**Recommendation Report for Listed Building Consent for Alterations, Extension or Demolition of a
Listed Building**

REF NO: A/39/26/L

LOCATION: St Margarets Church
Arundel Road
Angmering
BN16 4JS

PROPOSAL: Listed building consent for the installation of a single commemorative blue plaque on the external Vestry wall.

Angmering Parish Council
14805 - Aubrey Plaque V1.2

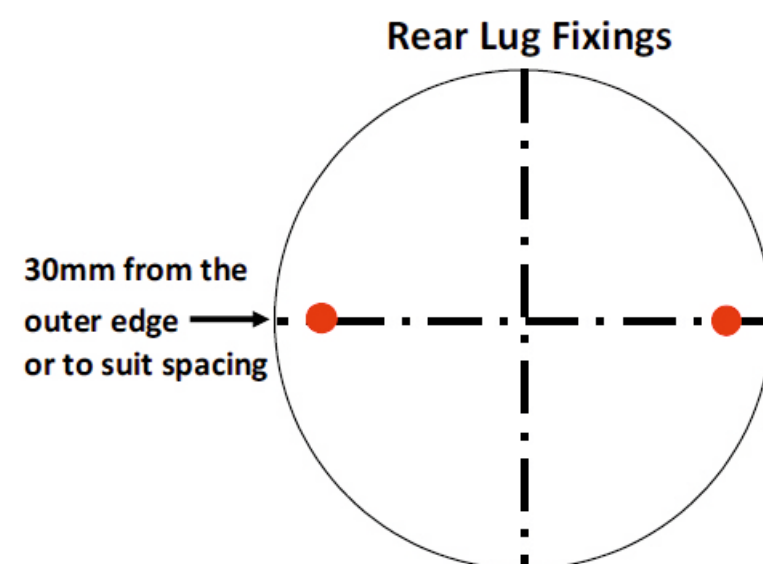
The plaque would be located on the corner of the building and be placed so that it would be clearly visible from the road, car park and general surroundings. It is assumed that it would be located on the brick detailing as indicated in the images supplied. although it is not clear how high up the building it would be located - you may wish to get this confirmed. The design of the plaque also looks to be acceptable in this sensitive context.

It is positive to note from the application that the installation will have minimal impact on historic fabric due to the use of reversible fixings placed in existing mortar joints. As a result, no historic fabric would be damaged.
